PCD File COM246

SHEET:
C-1

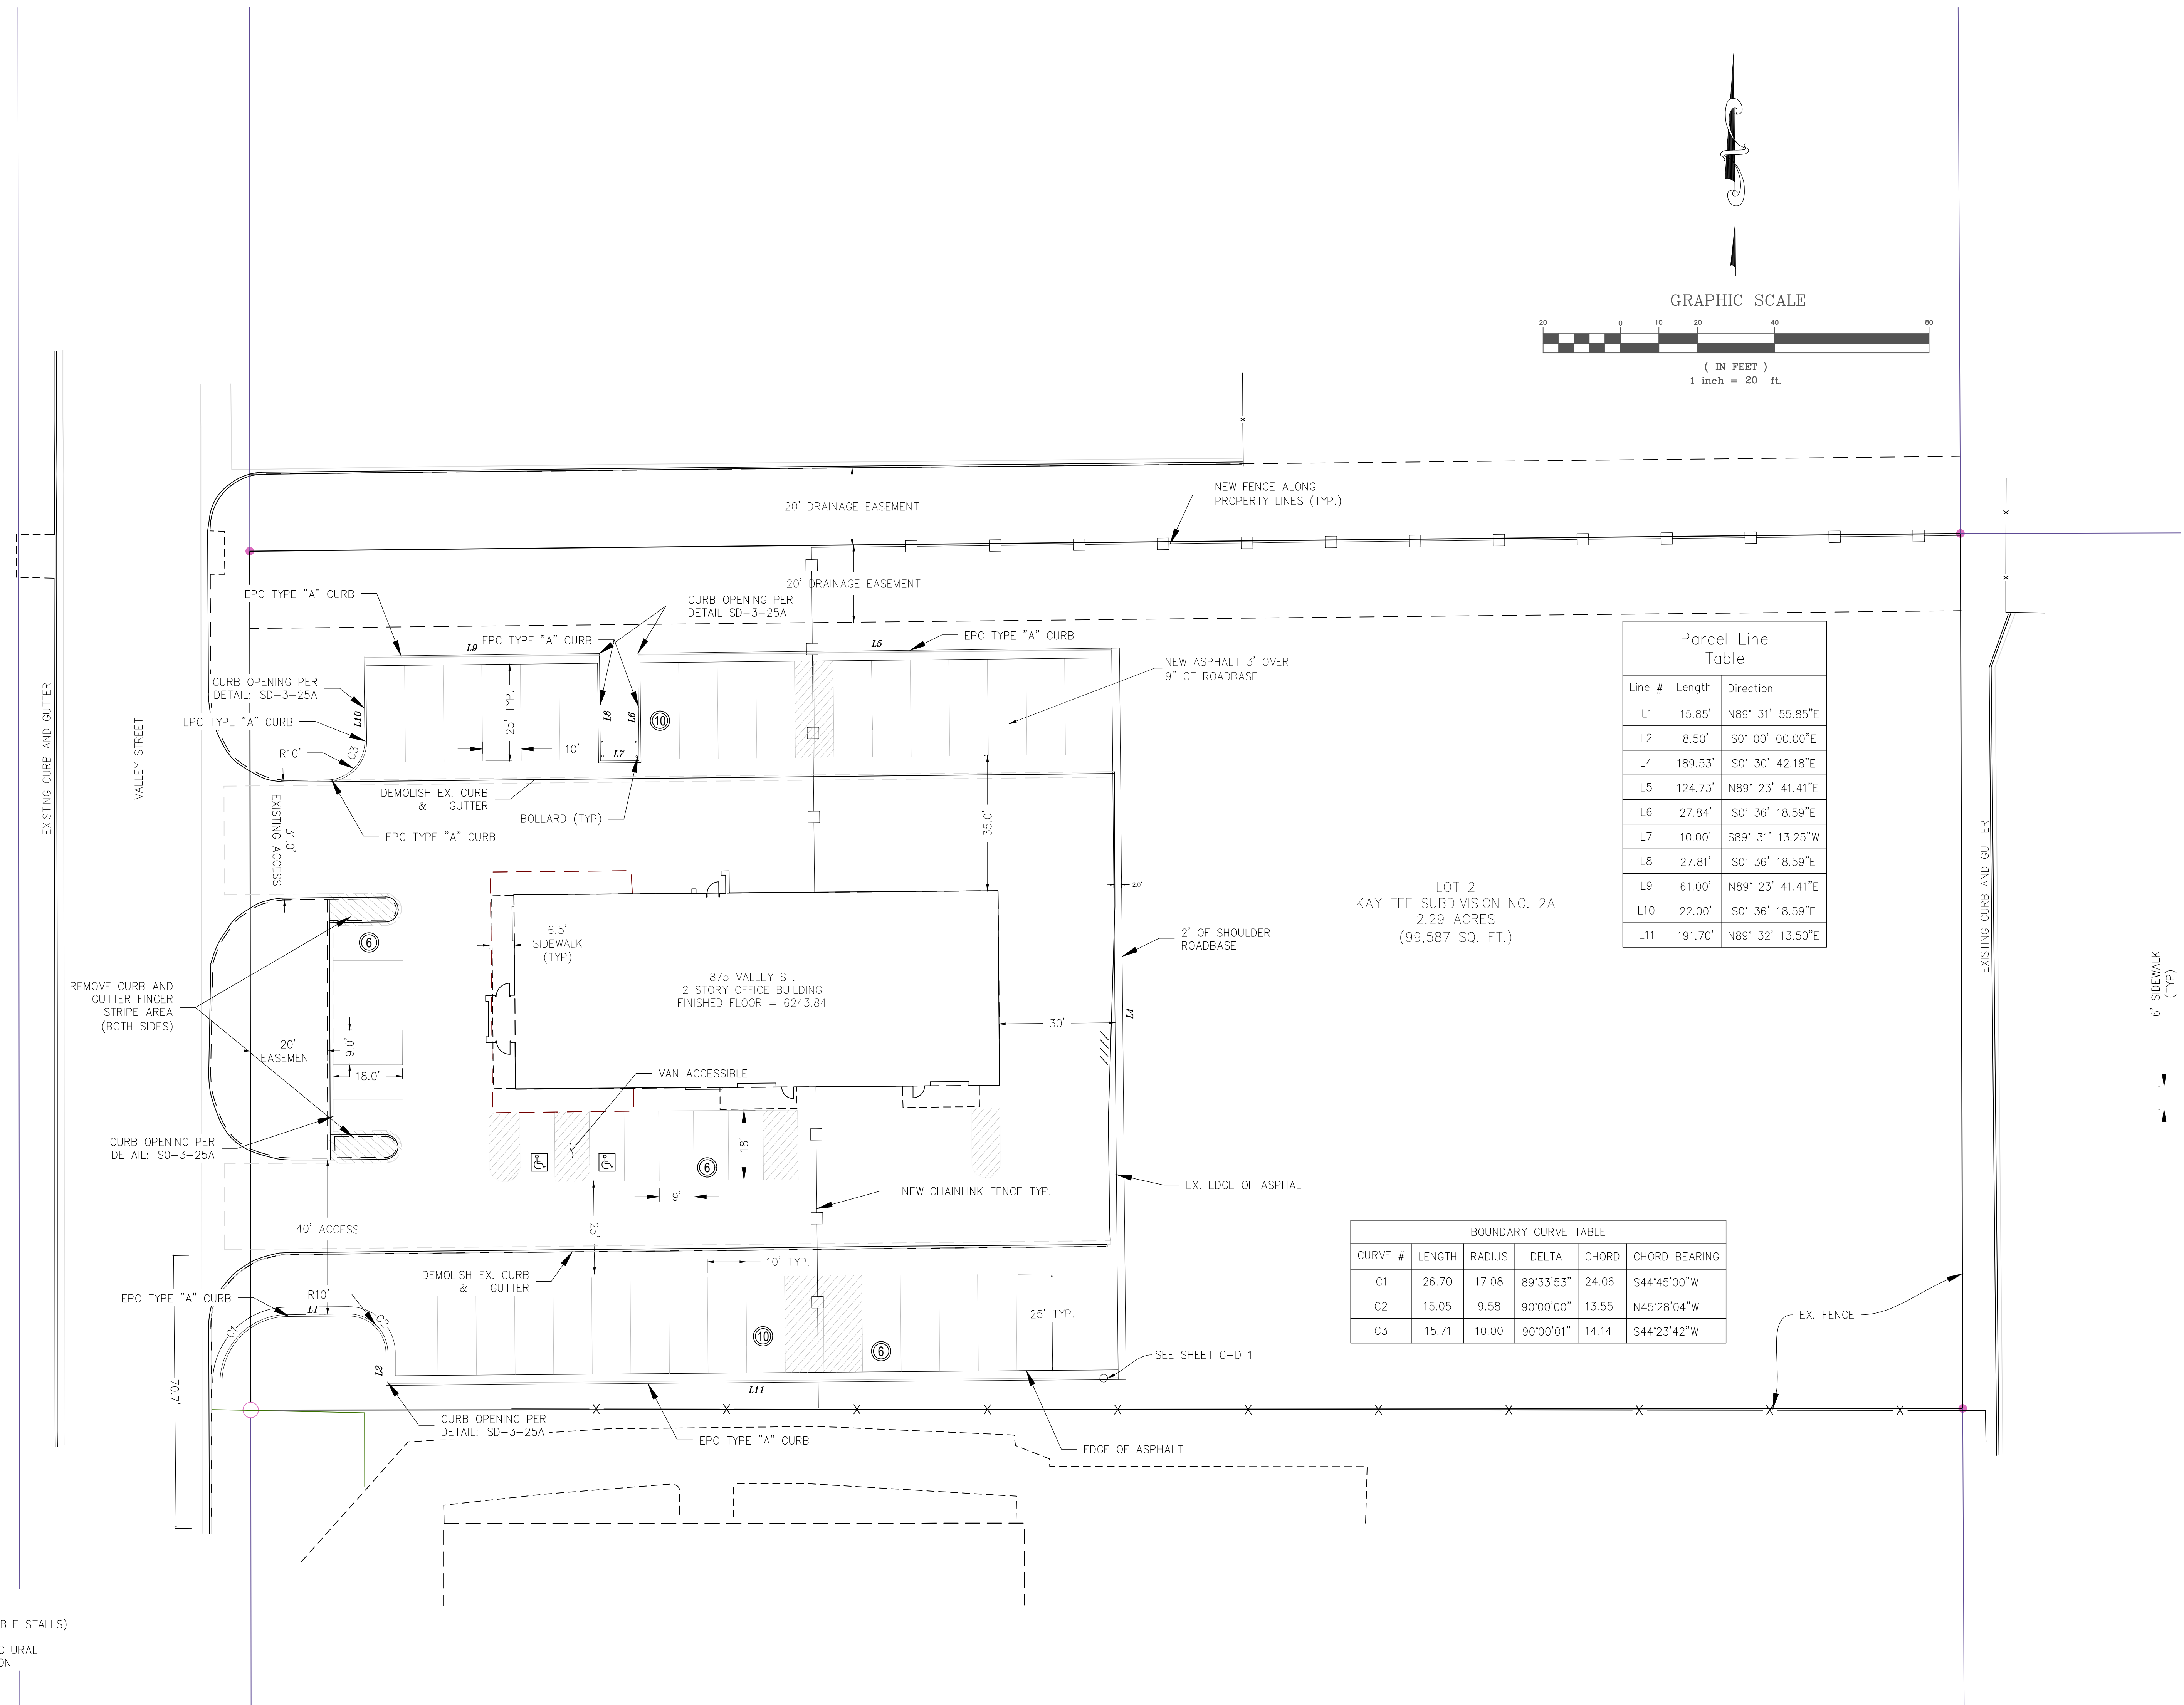
This appears to be off the lot. Please omit.

Add the following to site development plan:  
 - Vicinity Map  
 - Signature block the Planning and Community Development Director a minimum of 1 inch by 2 inches  
 - Location and dimensions of all existing and proposed signage on site  
 - Location of all garbage receptacles with a graphical depiction of the screening mechanism

The following note should be added to all site development plans or non-residential site plans, as applicable, prior to PCD approval:  
 The parties responsible for this plan have familiarized themselves with all current accessibility criteria and specifications and the proposed plan reflects all site elements required by the applicable ADA design standards and guidelines as published by the United States Department of Justice. Approval of this plan by El Paso County does not assure compliance with the ADA or any regulations or guidelines enacted or promulgated under or with respect to such laws.

Please add the property boundary line and distances. Clarify line types with legend. Eastern property line is not clear

Add 60ft ROW
